**Consultation Response from KC,
Highways Development Management****2025/92718 16, High Green, Lepton, Huddersfield, HD8 0HW****Erection of rear extension and associated alterations****Date Responded: 06/01/2026****Responding Officer: CNB****Responding Ref: K11-23/1**

BLOCK PLAN 1:500

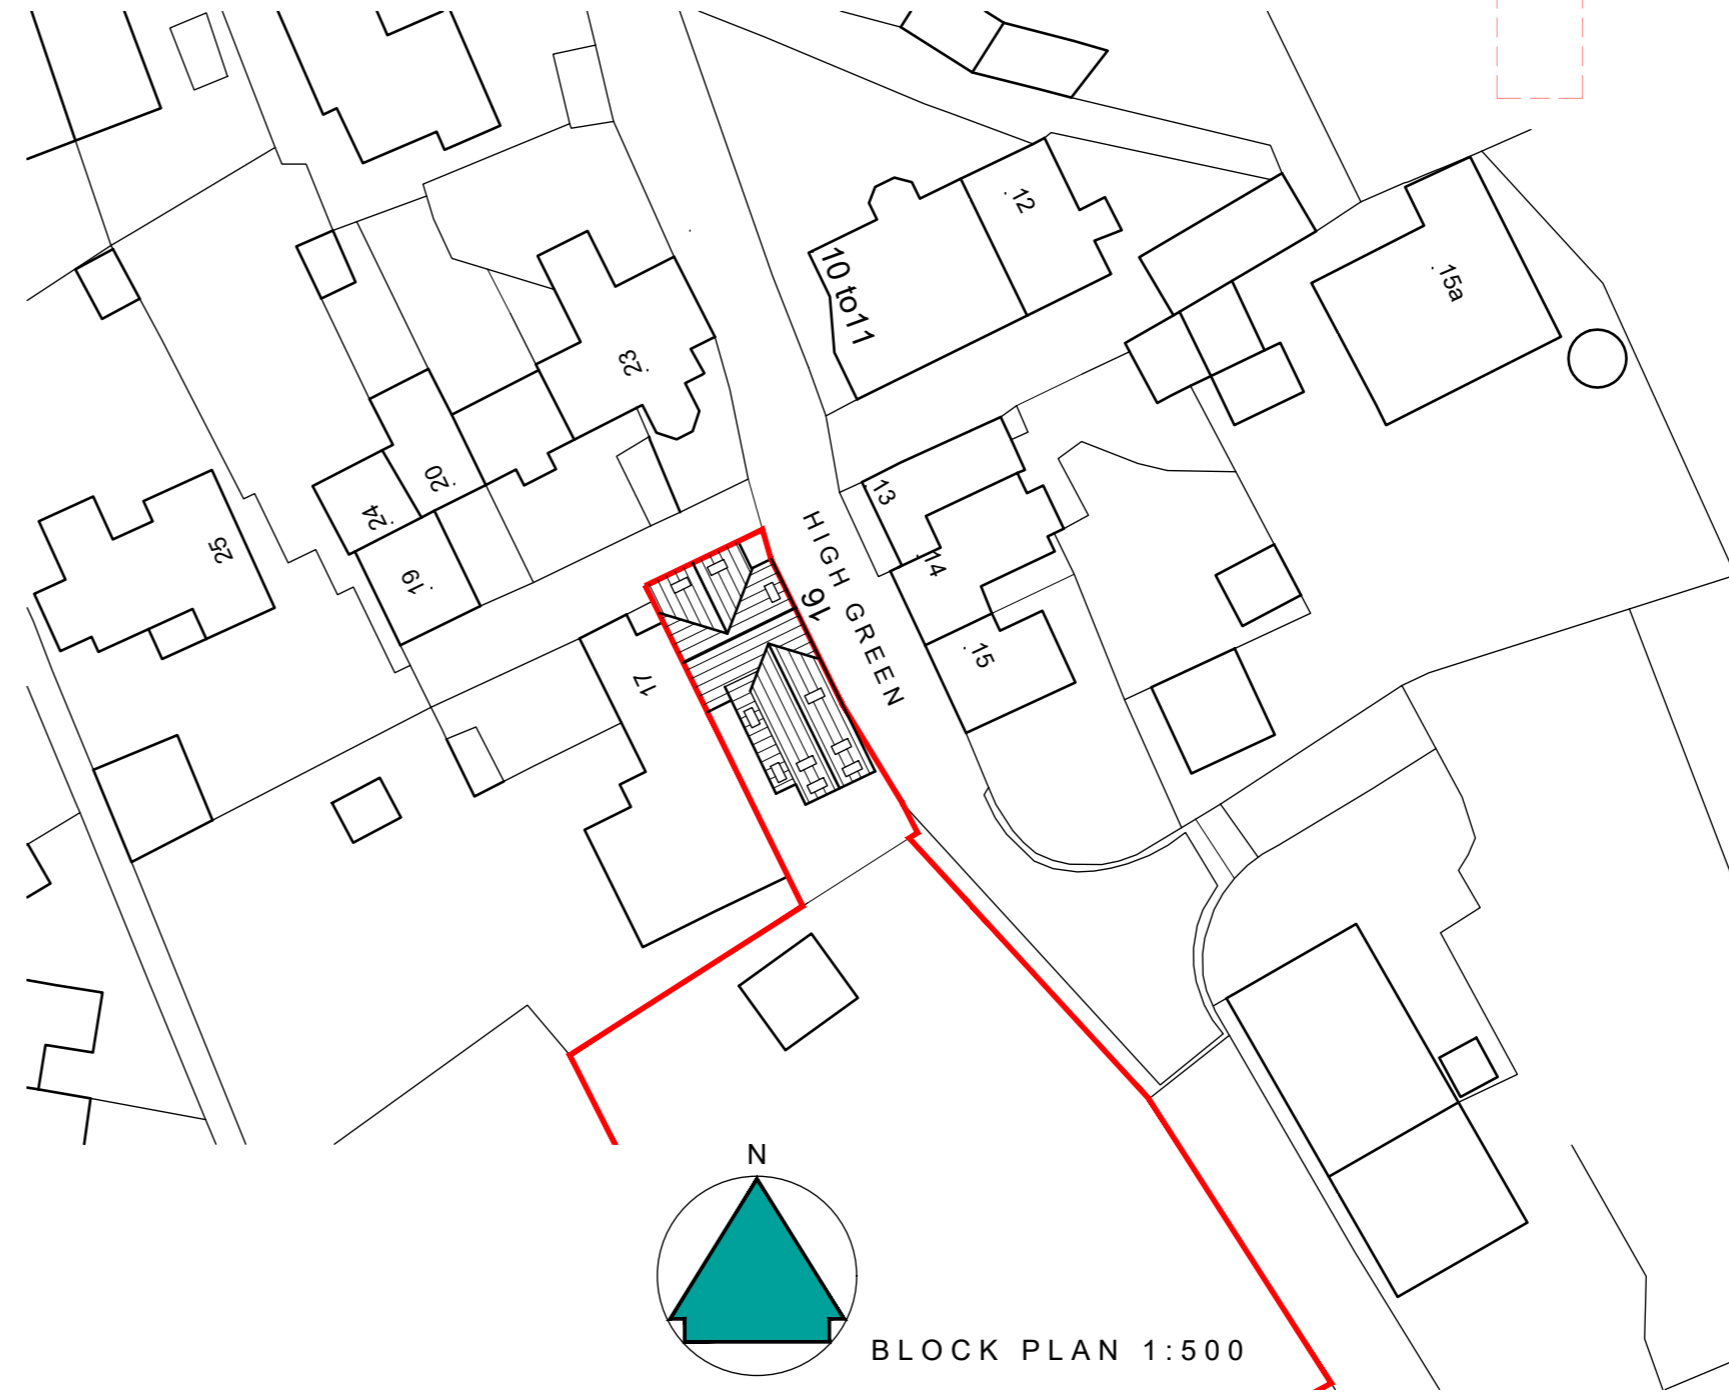
The proposals will increase the dwelling from 3 bedrooms to 4 bedrooms with other additional living space. This increase would require 3 off-street parking spaces to be provided. Although there are no drawings submitted with the application that indicates that 3 parking spaces can be achieved, the driveway to the rear of the site is of suitable size to fit 3 parked vehicles with turning space and there is also a garage available if required. Parking details should be conditioned.

Notwithstanding the details shown on the approved plan, no development shall take place until a scheme detailing arrangements and specification for layout of parking have been submitted to and approved in writing by the Local Planning Authority. Before any building is occupied the development shall be completed in accordance with the details shown on the approved plans and retained thereafter.
